From: Luke Challenger [REDACTED]
Sent: 13 July 2021 15:27
To: Tim Townsend
Cc: Simon Davis
Subject: Y/18/21/RES - Clays Farm North End Road Yapton BN18 0DT
Attachments: RE: Yapton; MBSK210702-01 P3.pdf; MBSK210702-02.pdf

I also attach the updated access road plan (as submitted previously) for ease of reference that incorporates your suggestion to shift the bellmouth slightly further north to allow for a revised pedestrian footway. The plans also show a rumble strip and white lining to indicate pedestrian movement, as requested.

MBSK210702-01

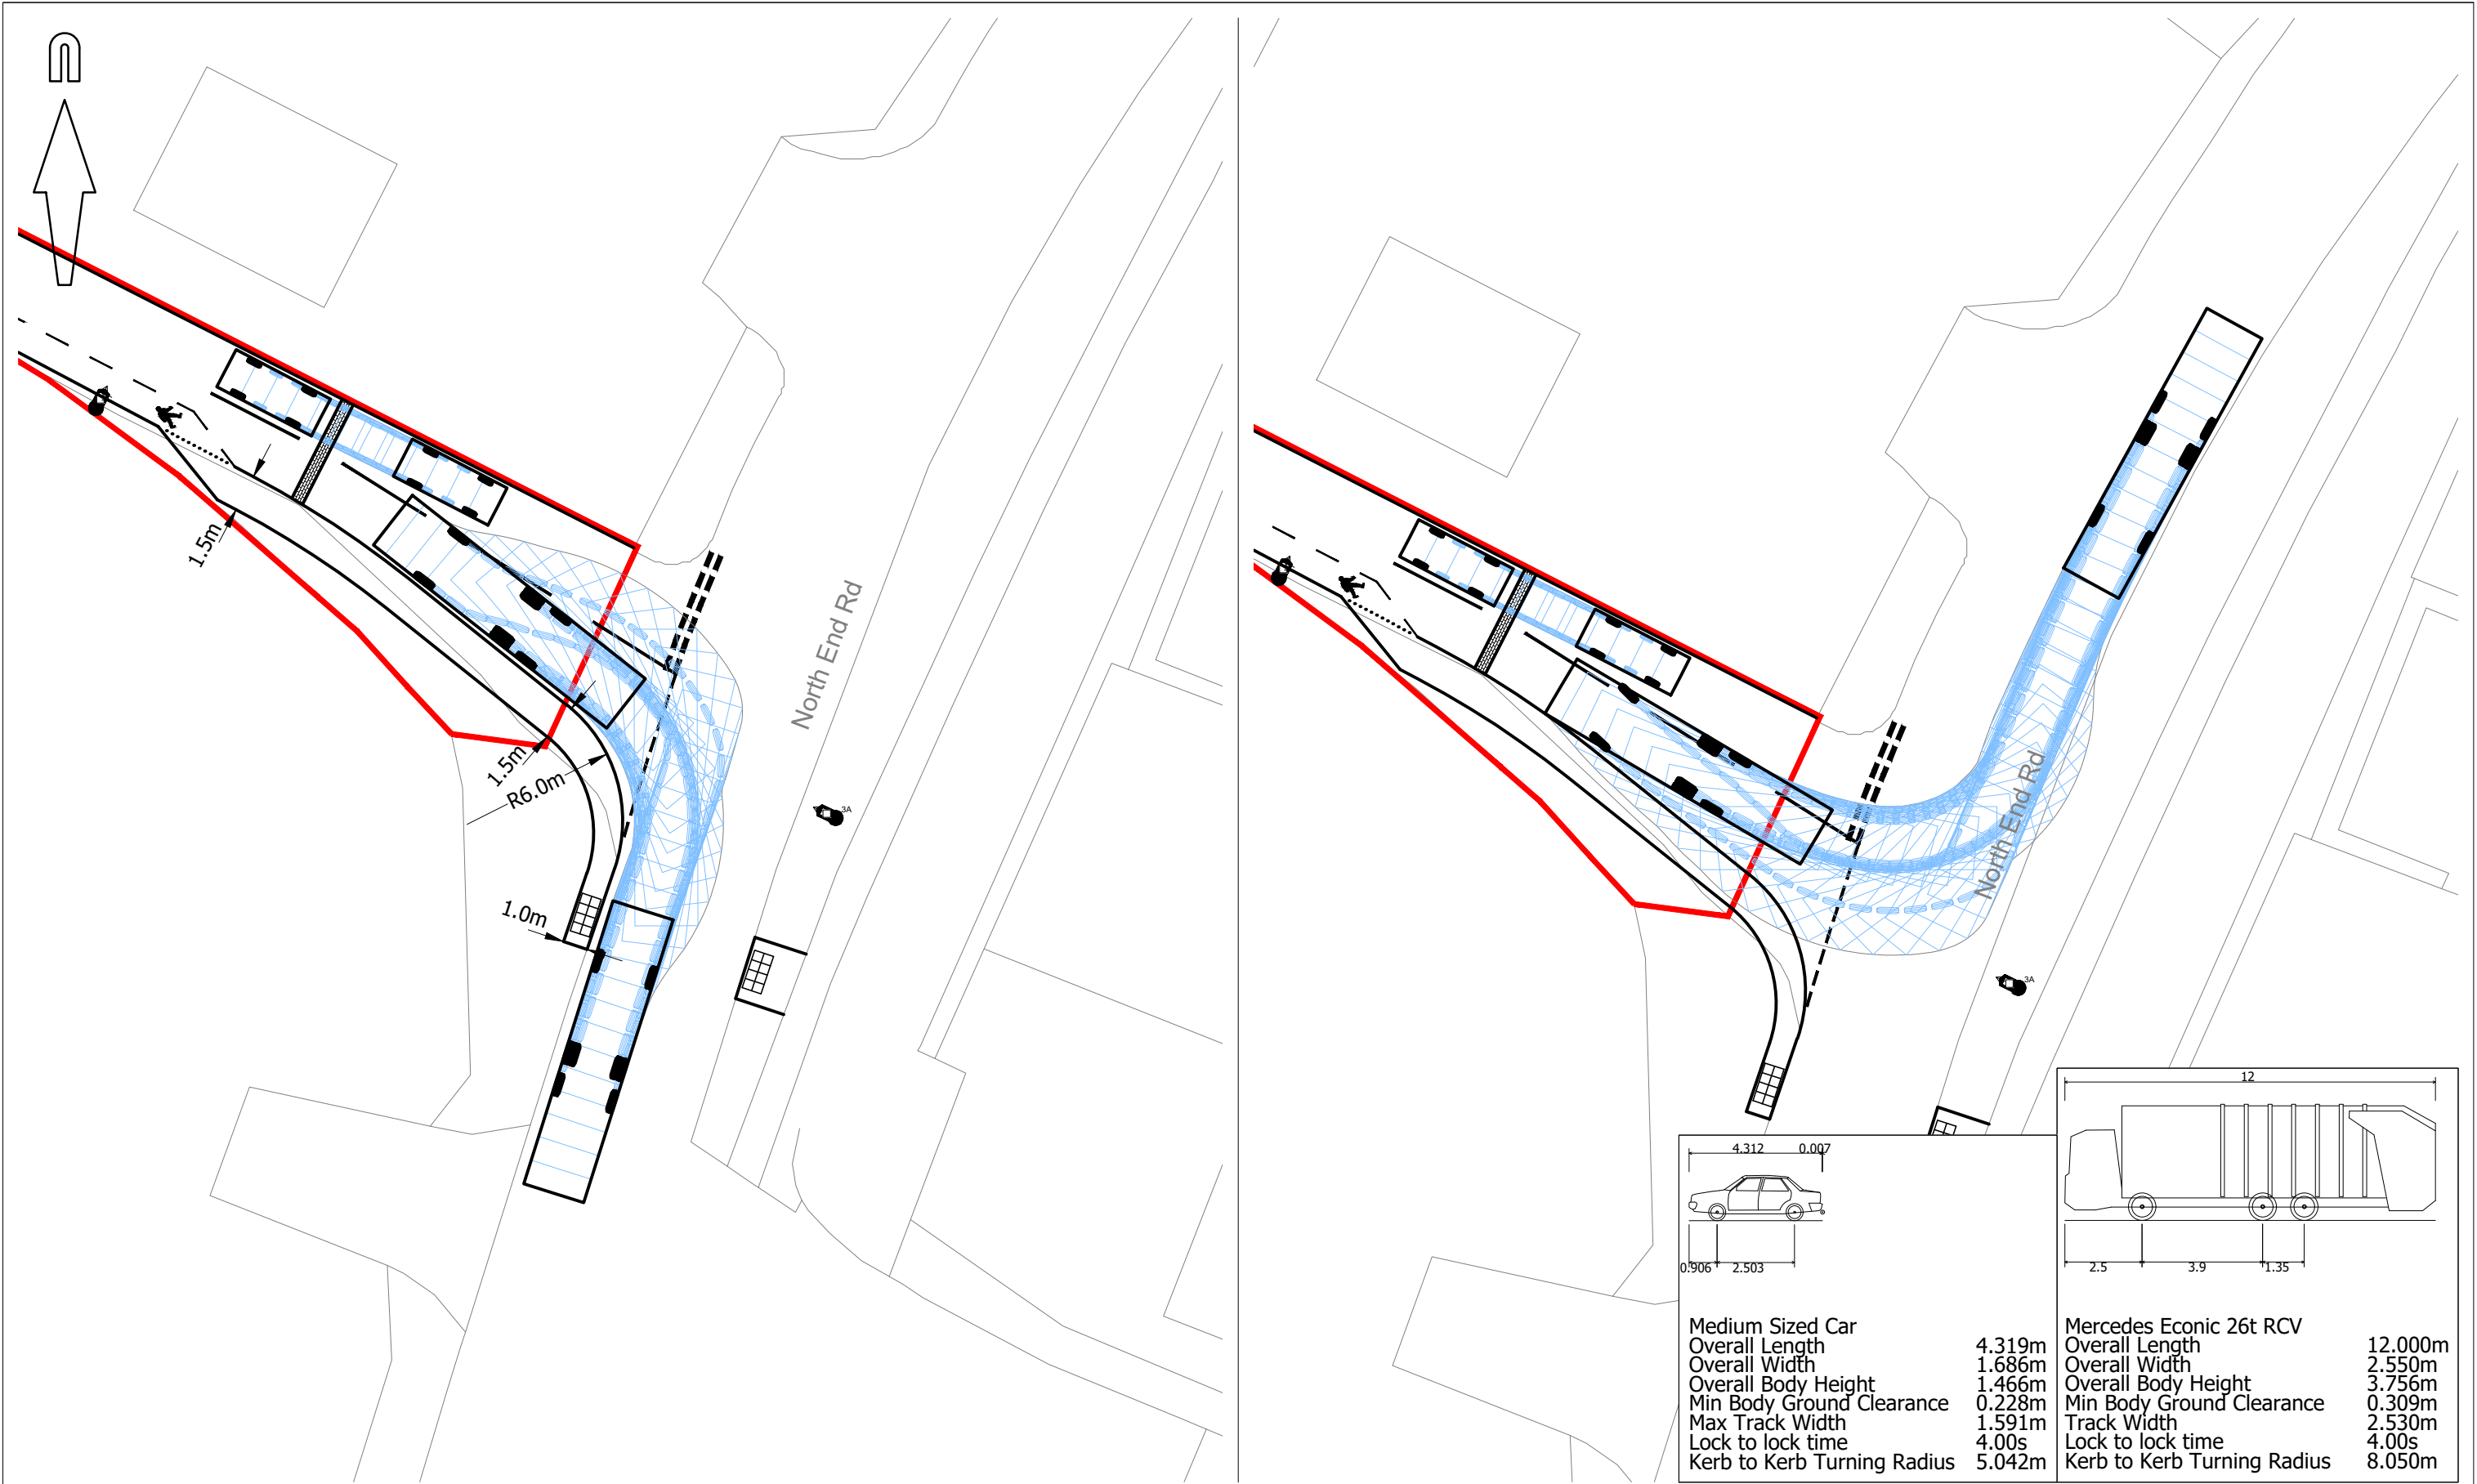
Following our discussions we have received confirmation from the Highway Consultant's RSA team that there will be no material increase in risk to road users as a result of the latest proposals, please see attached.
